Phone: 0300 123 6780  
Email: [developeras@lancashire.gov.uk](mailto:developeras@lancashire.gov.uk)  
Your ref: 3/2025/0680  
Our ref: 3/2025/0680/HDC/KW  
Date: 10 September 2025

**Location:** 12 Northcote Park Langho Blackburn BB6 8FB  
**Proposal:** Proposed garage conversion.  
**Grid Ref:** 370552 434610

A1.2

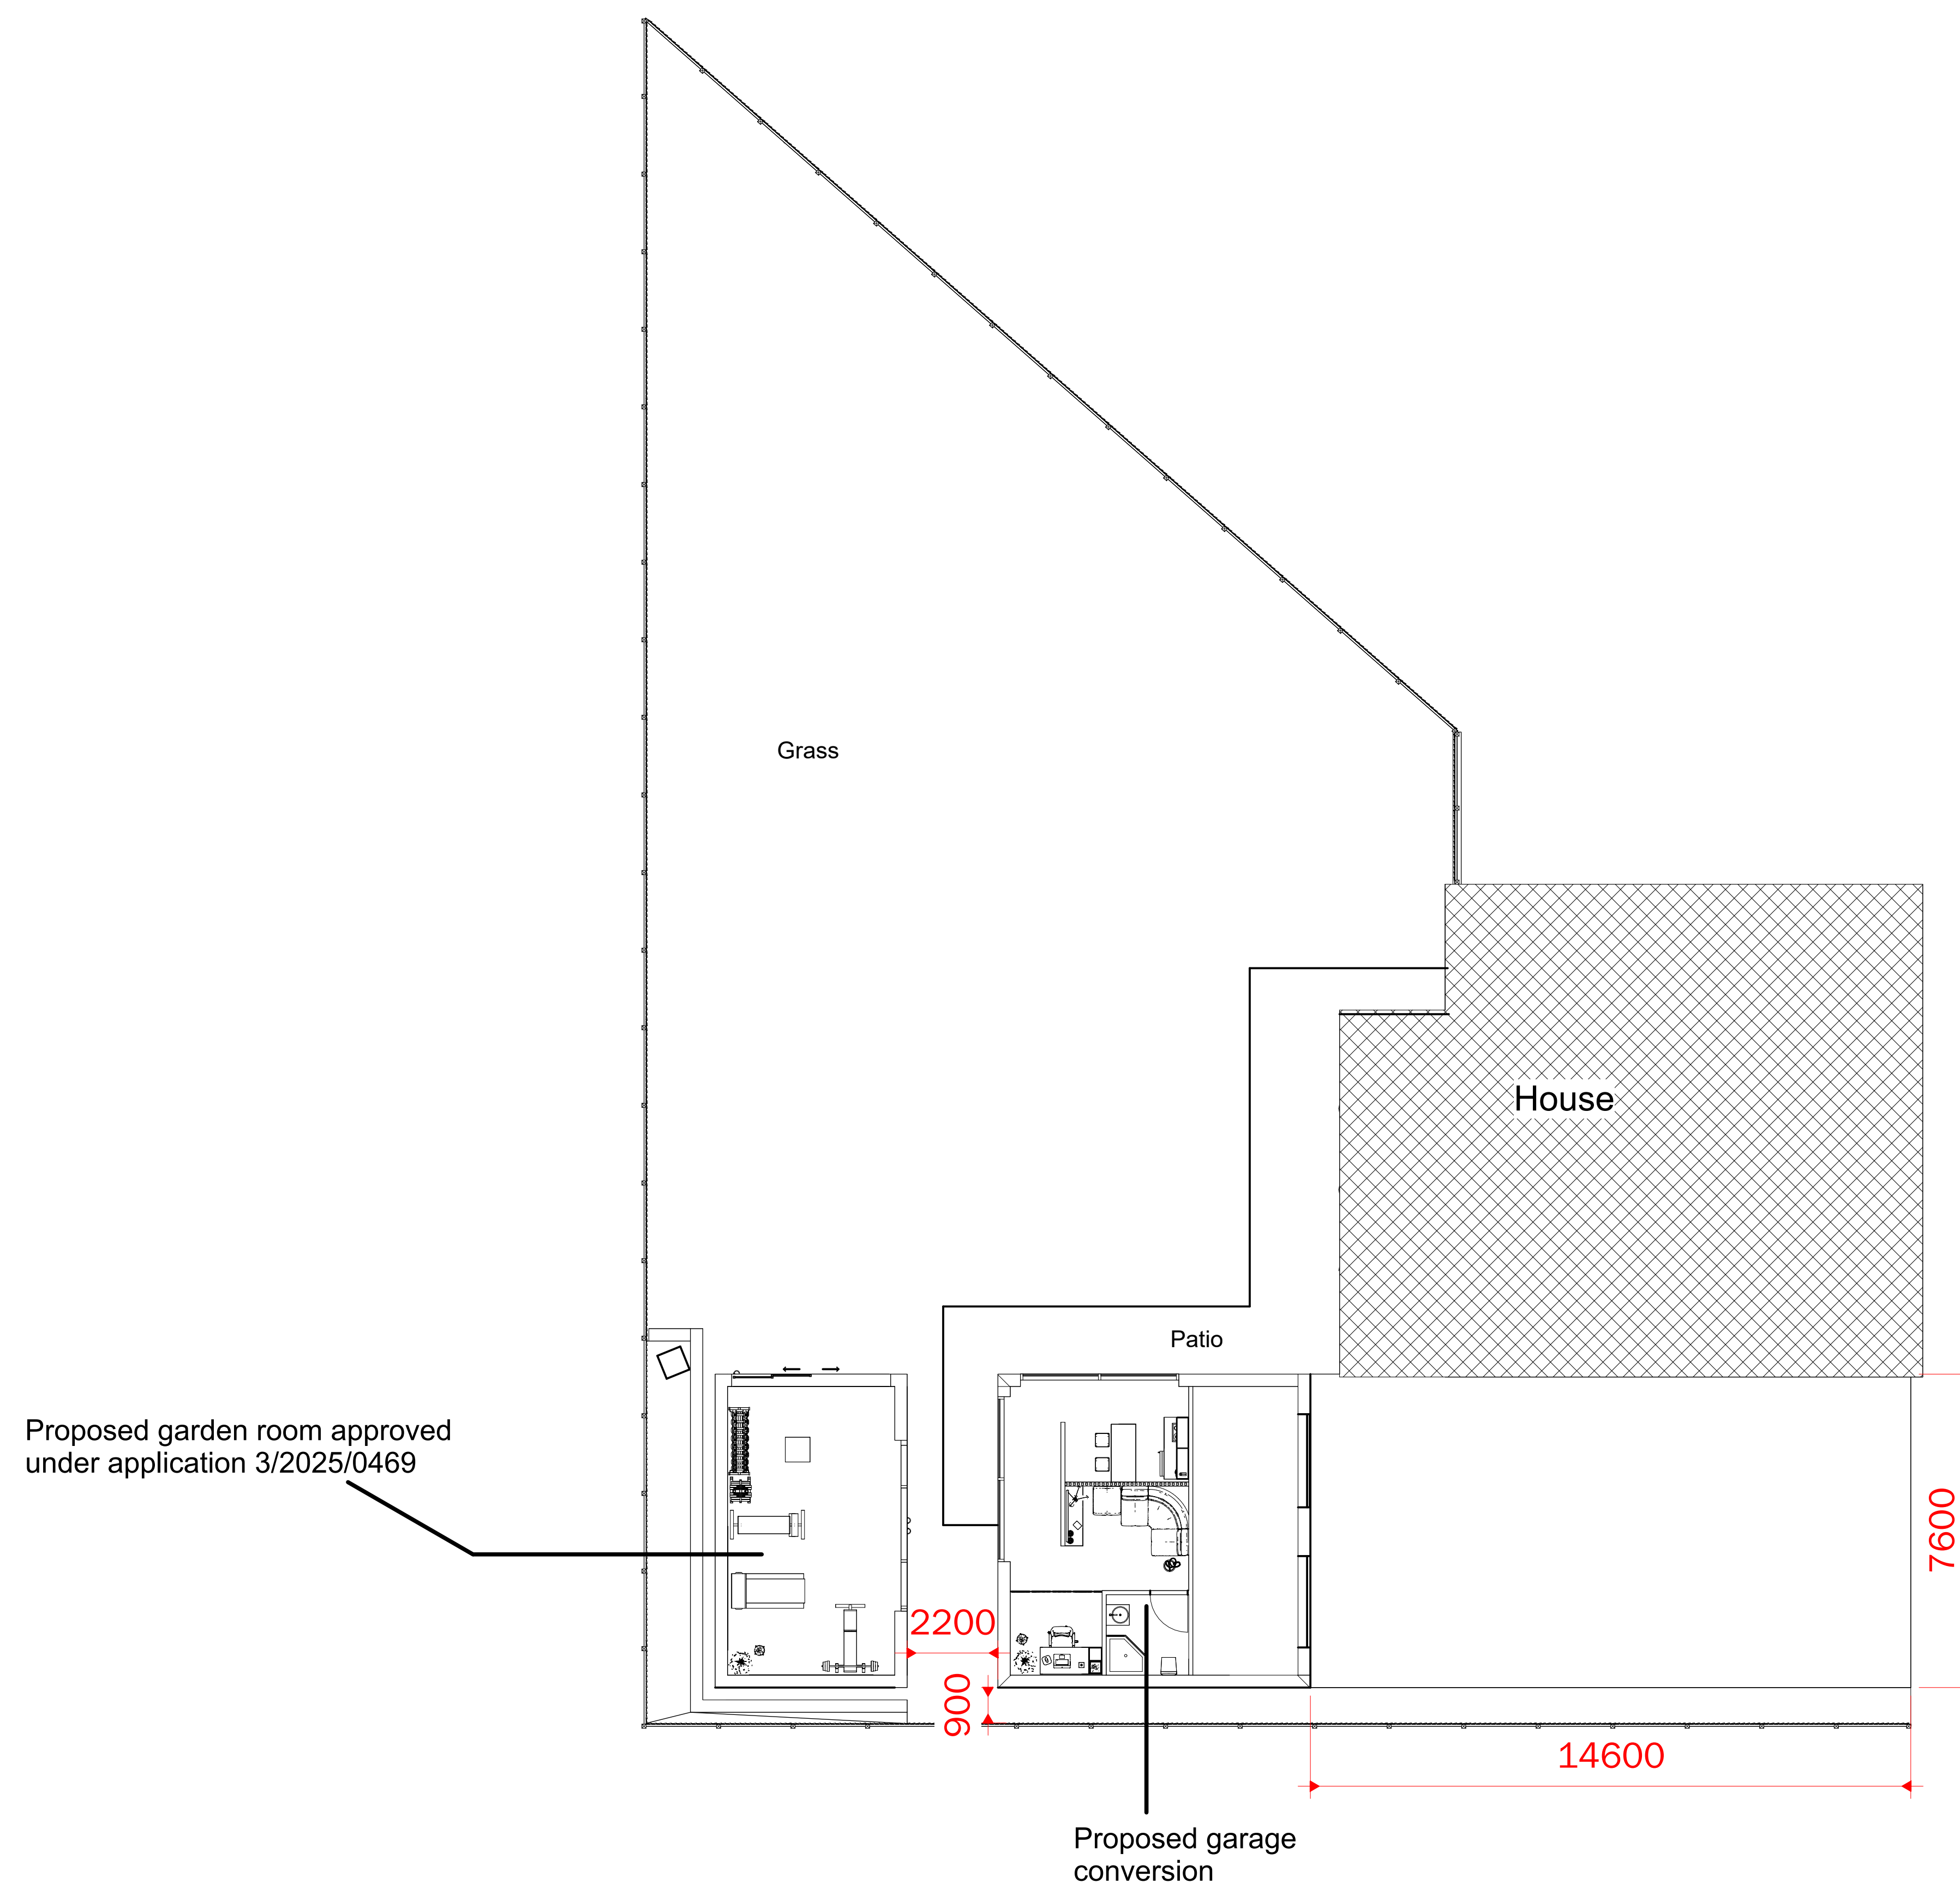
The LHA are aware that the site access will remain unaltered following the proposal. The LHA have reviewed drawing number A1.2 titled "Proposed Site Plan" and are aware that whilst the garage will be removed, the existing driveway will be retained, providing 4 off-street parking spaces. As such the dwelling complies with the LHAs parking standards as defined in the Joint Lancashire Structure Plan. Therefore, the LHA have no objection to the proposal.

A section of storage area will also be retained, which could provide covered secure cycle storage, which was considered as part of the original Northcote Park development by the highway authority. This will ensure the provision and availability of adequate cycle parking and the promotion of sustainable forms of transport.
